**NSIP: A417 Missing link**

**User Code: TR010056**

**Rule 17 Request for further information and Hearing Action Points**

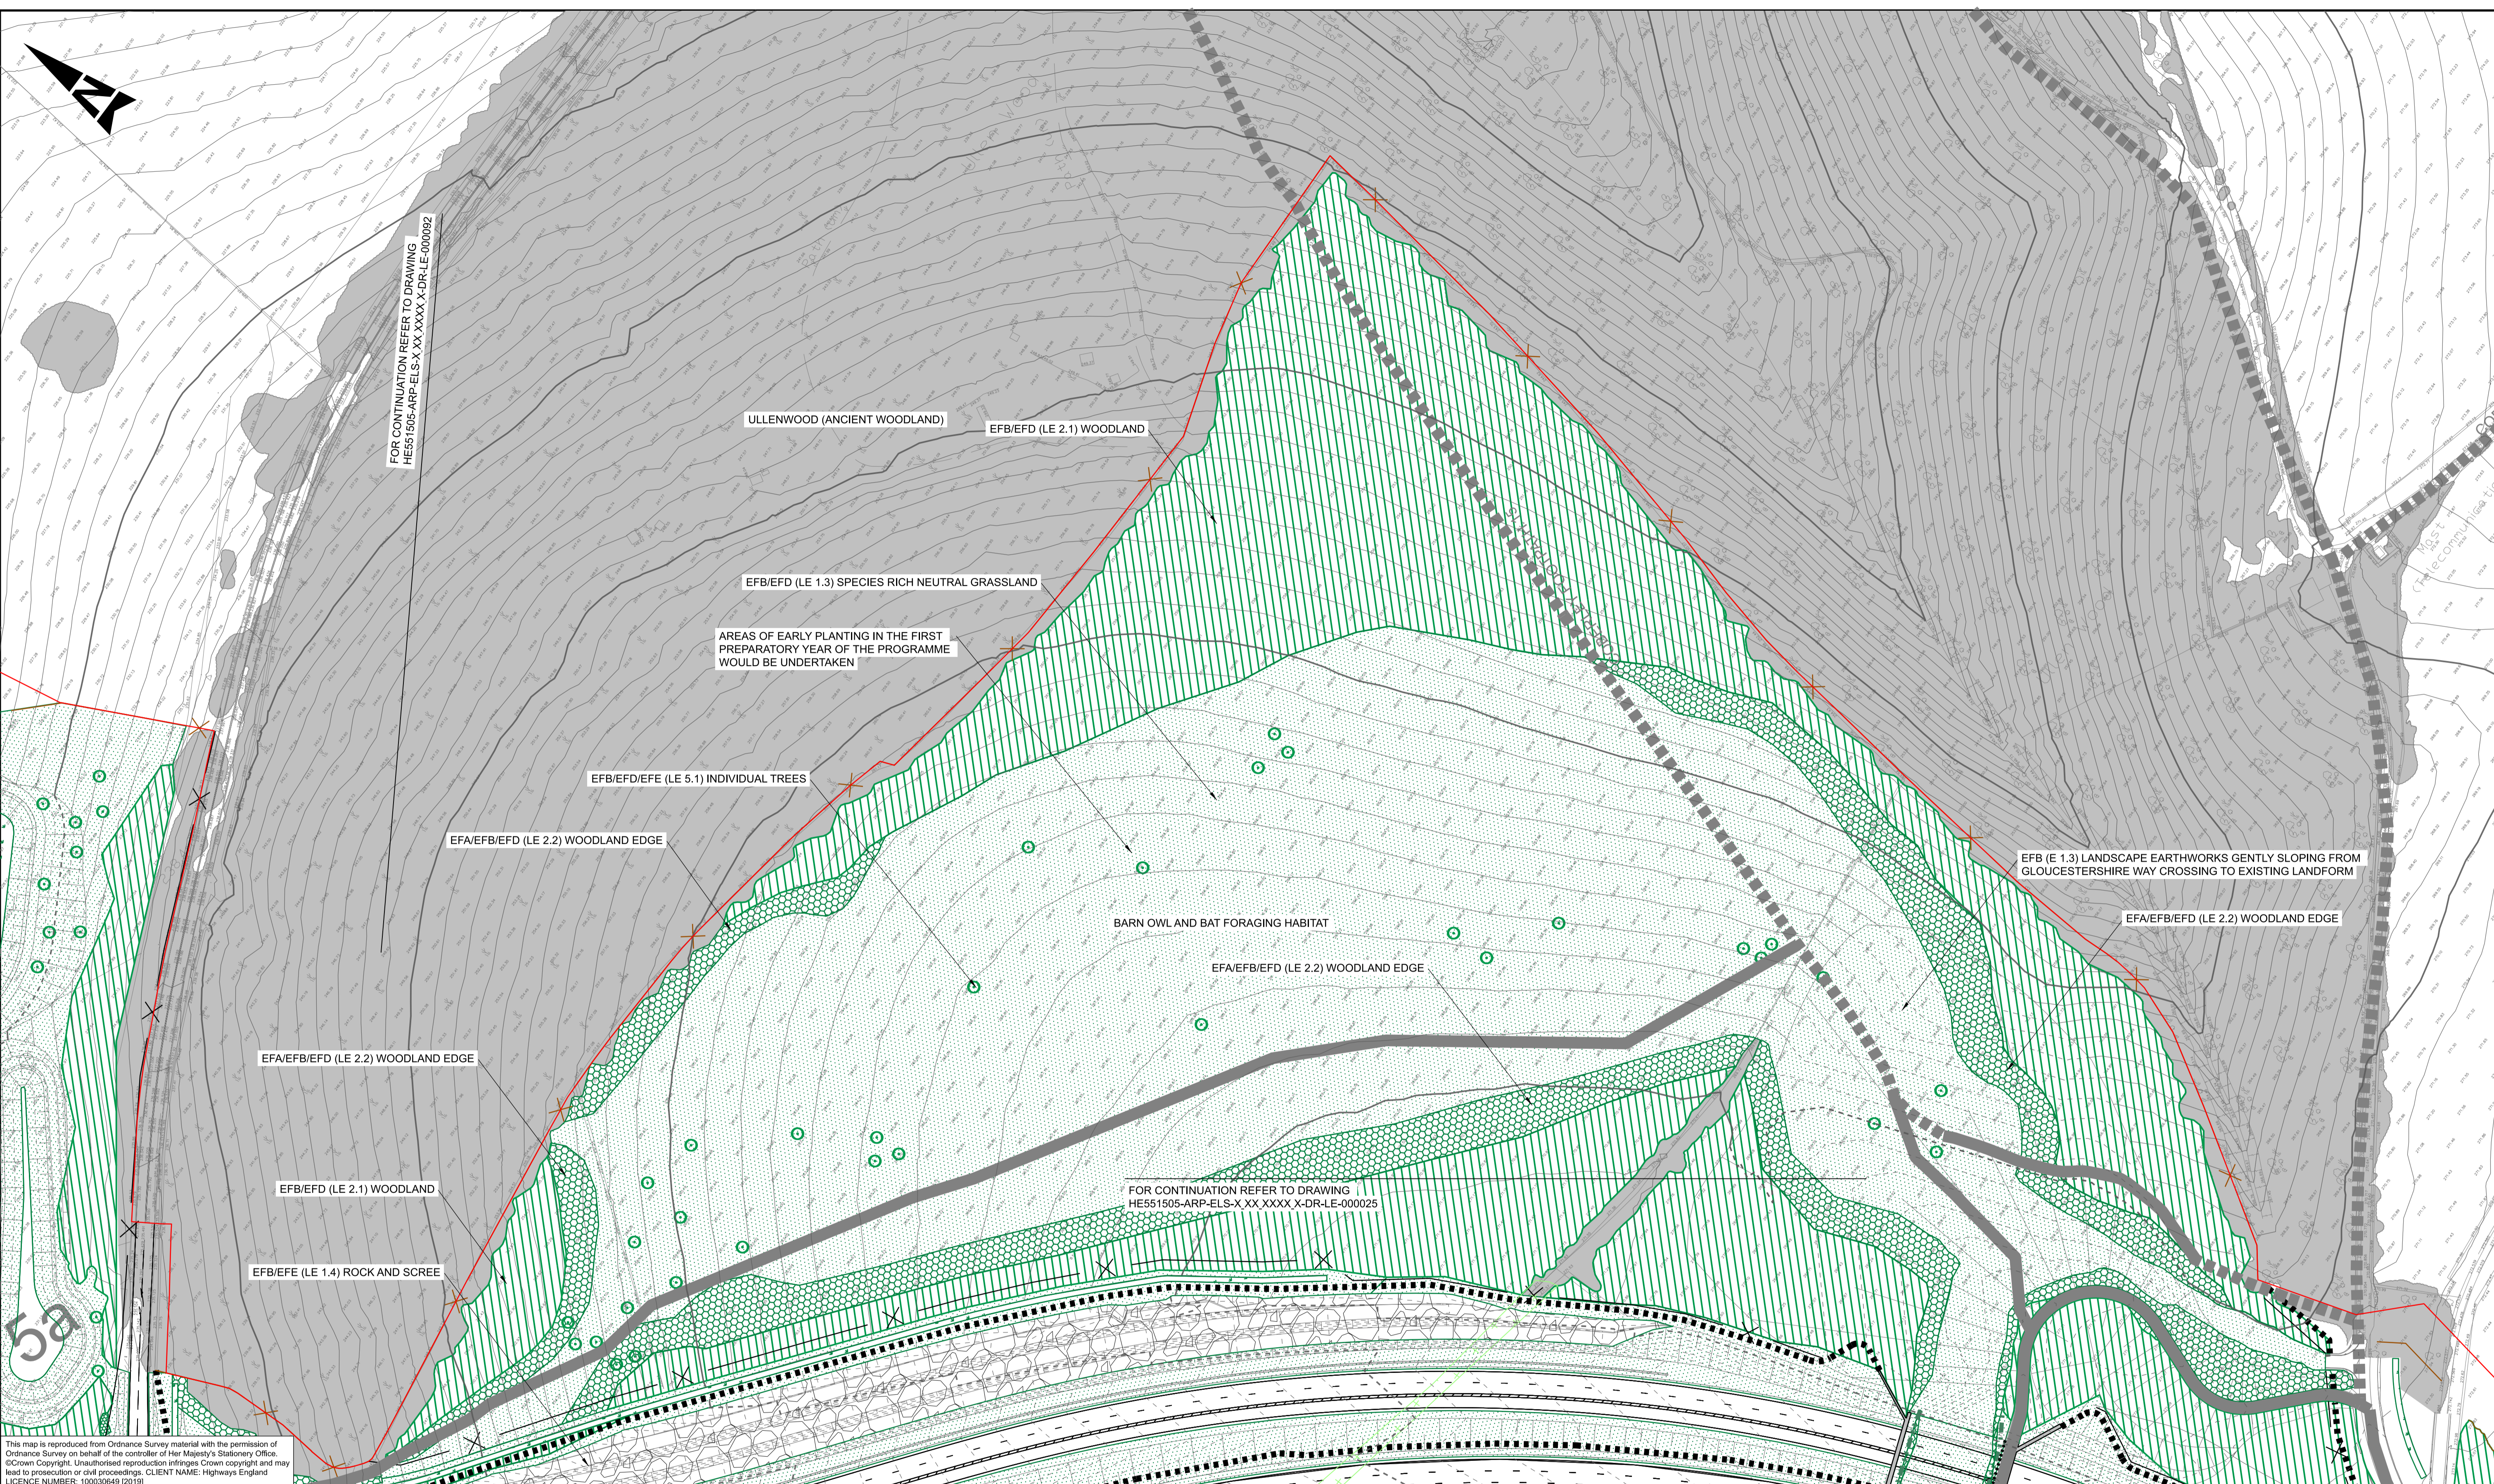
Natural England accepts that the scheme impacts are unavoidable with this route and that mitigation is not possible. We therefore accept the principle of compensation, in this specific case (Written Representation paragraph 4.53).

The Environmental Statement sets out that approximately 5ha of mixed broadleaved woodland and a buffer of scrub species would be planted around the borders of a field to the south of Ullen Wood (8.9.32 and as shown in ES Figure 7.11 Environmental Masterplan (Document Reference 6.3). In addition National Highways has committed to explore opportunities to contribute towards the enhancement of Ullen Wood through improvements to its management. Natural England is satisfied that the compensation proposed is appropriate in the circumstances. This subject is included in our Statement of Common Ground with National Highways, in the 'matters agreed' section.
